DEVELOPMENT SERVICES GROUP

July 12, 2017

RE: Notice of In-Completeness for File No. CAO17-007
4634 East Mercer Way, Mercer Island, WA 98040; King County Tax Parcel # 7558700008

A1.01

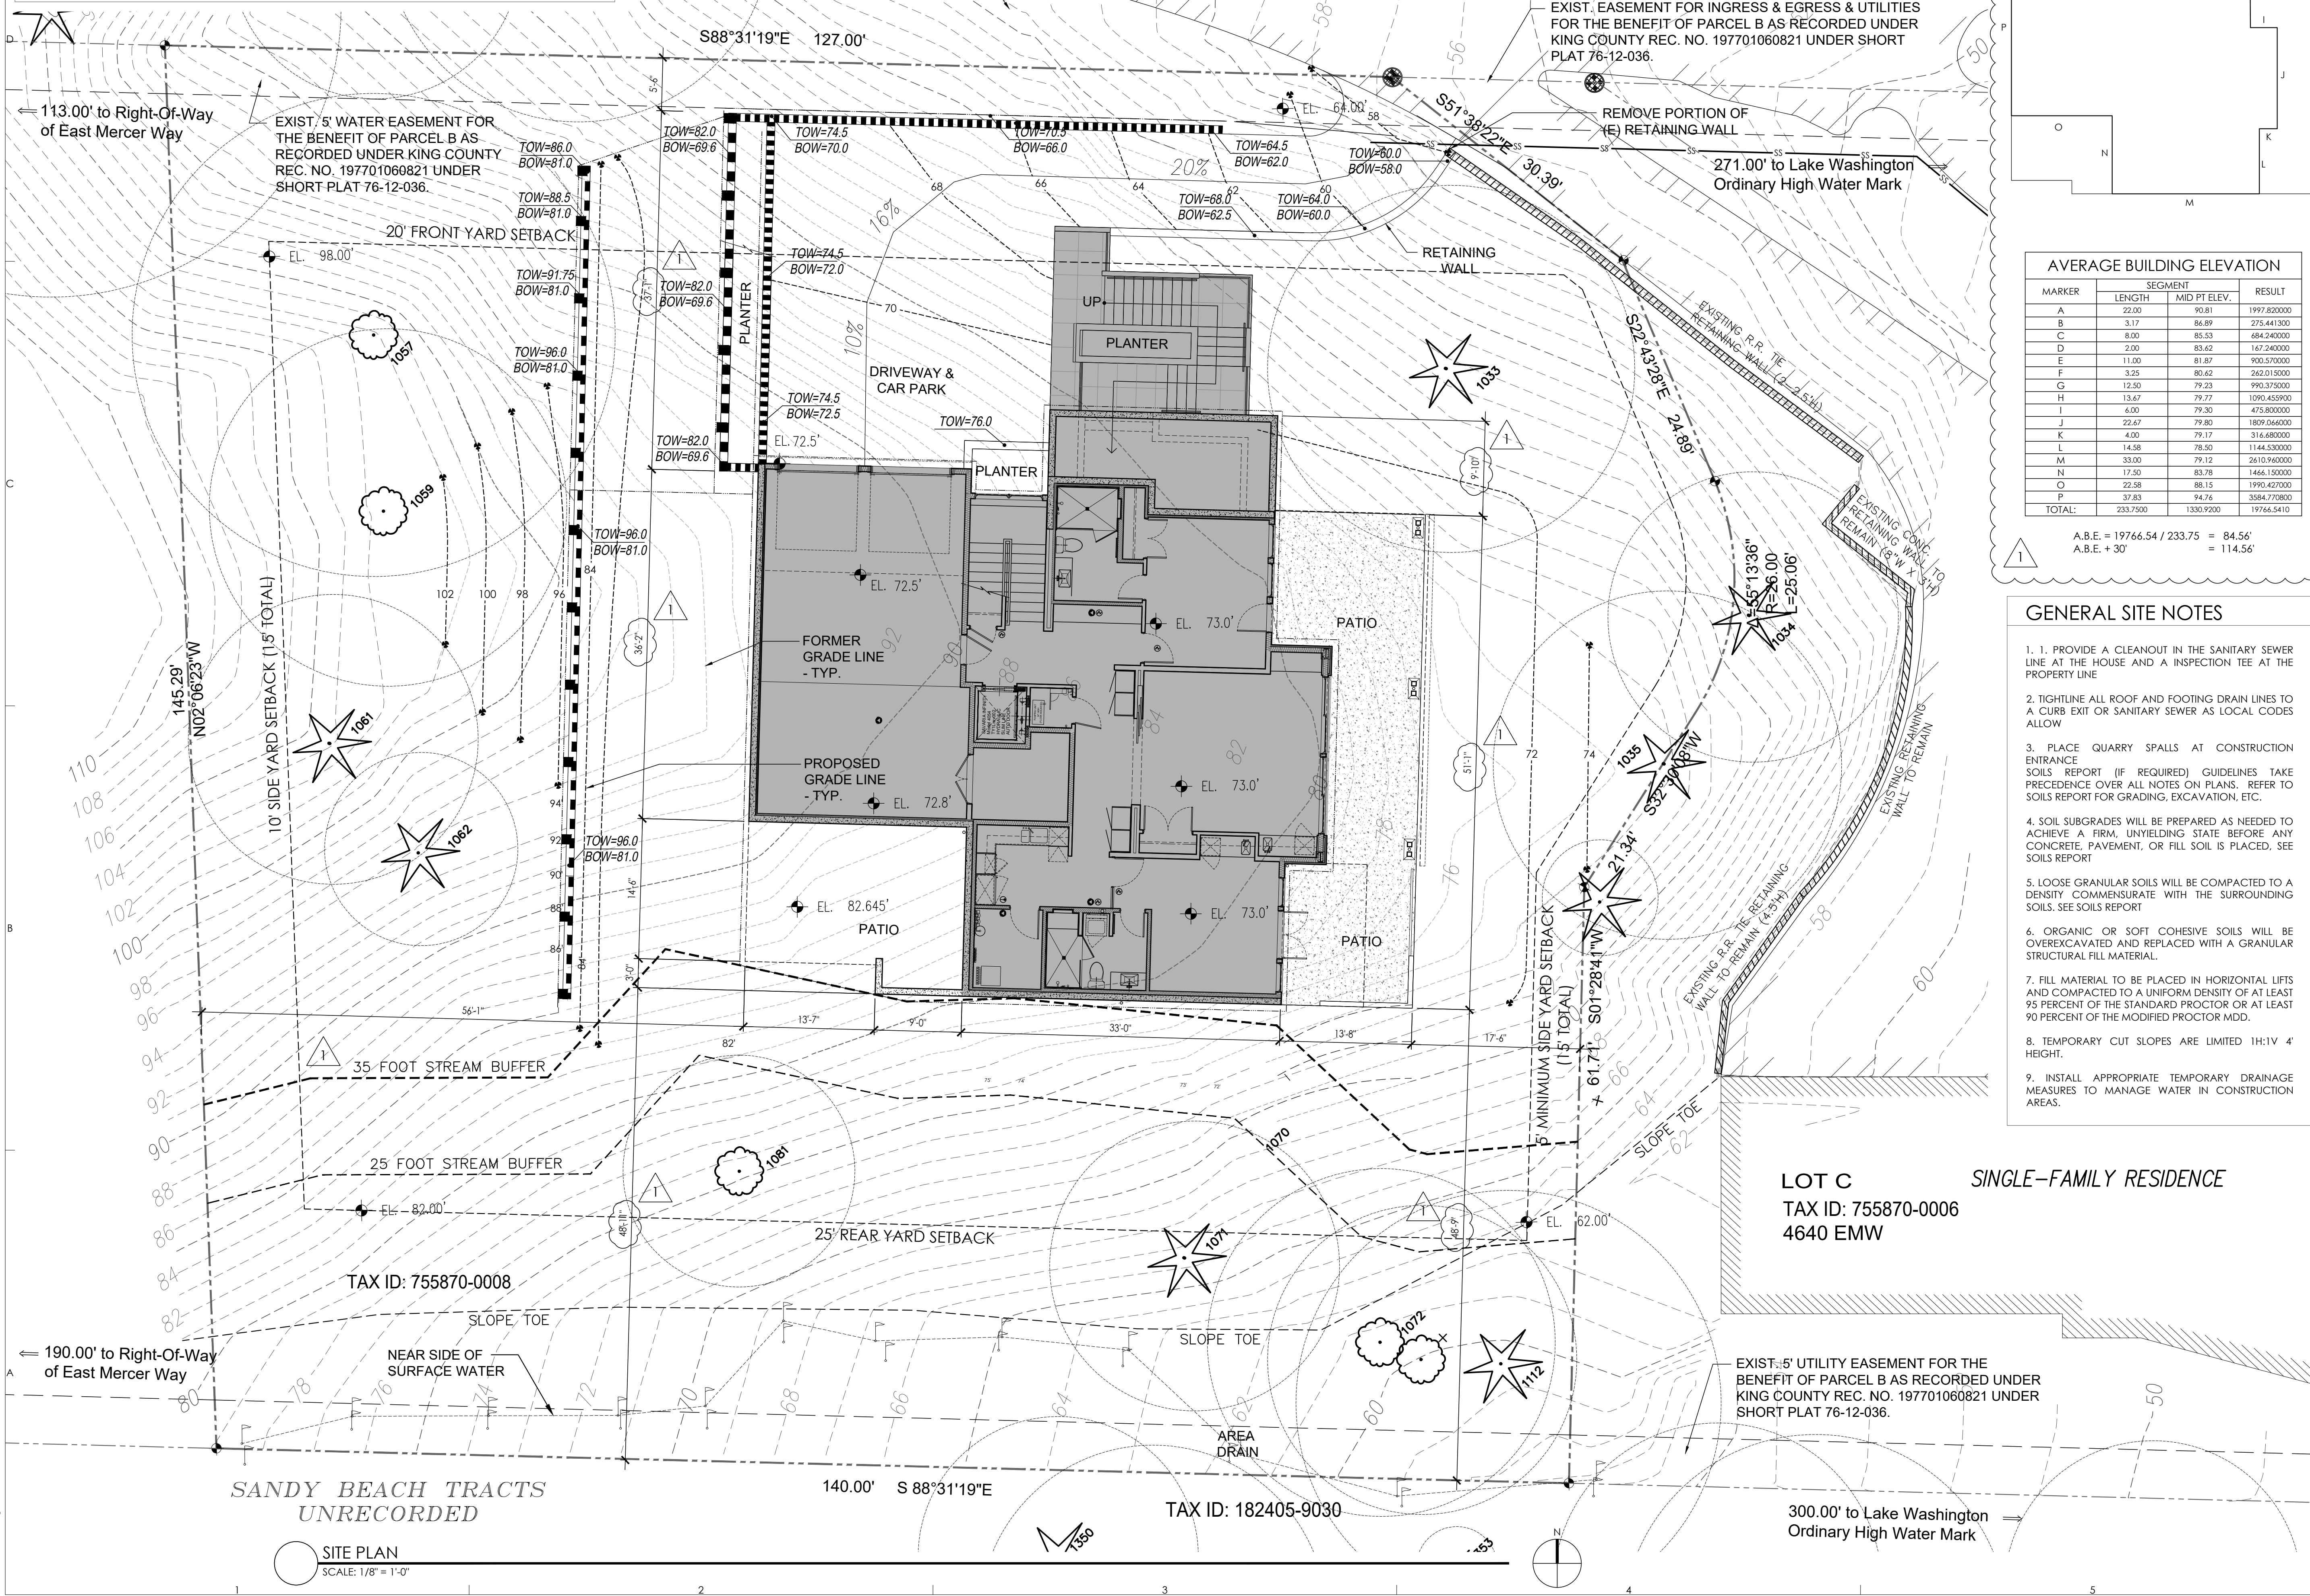
1. The application sheet indicates "Applicant requests critical areas determination for alteration of steep slope and steep slope buffer." However, the site plan reflects a watercourse and two possible watercourse buffer configurations; a modification of the watercourse buffer also requires a critical areas determination. No other application material describing the scope of the critical areas determination is provided. *Please clarify the scope of the requested critical areas determination.*

2. It appears that the critical areas determination or subsequent construction may result in alteration of a watercourse buffer area. If the watercourse or buffer area will be altered, it appears that work may occur on lands covered by water, requiring SEPA review. *Please clarify if any construction work will occur within the watercourse buffer area, or if the buffer width will be altered in any way. Please provide a SEPA checklist if work is proposed on lands covered by water.*

3. The site plans do not reflect the location of steep slope hazard areas subject to the proposed alteration. *Please revise the site plans to identify the location of all areas that meet the definition of steep slope.*
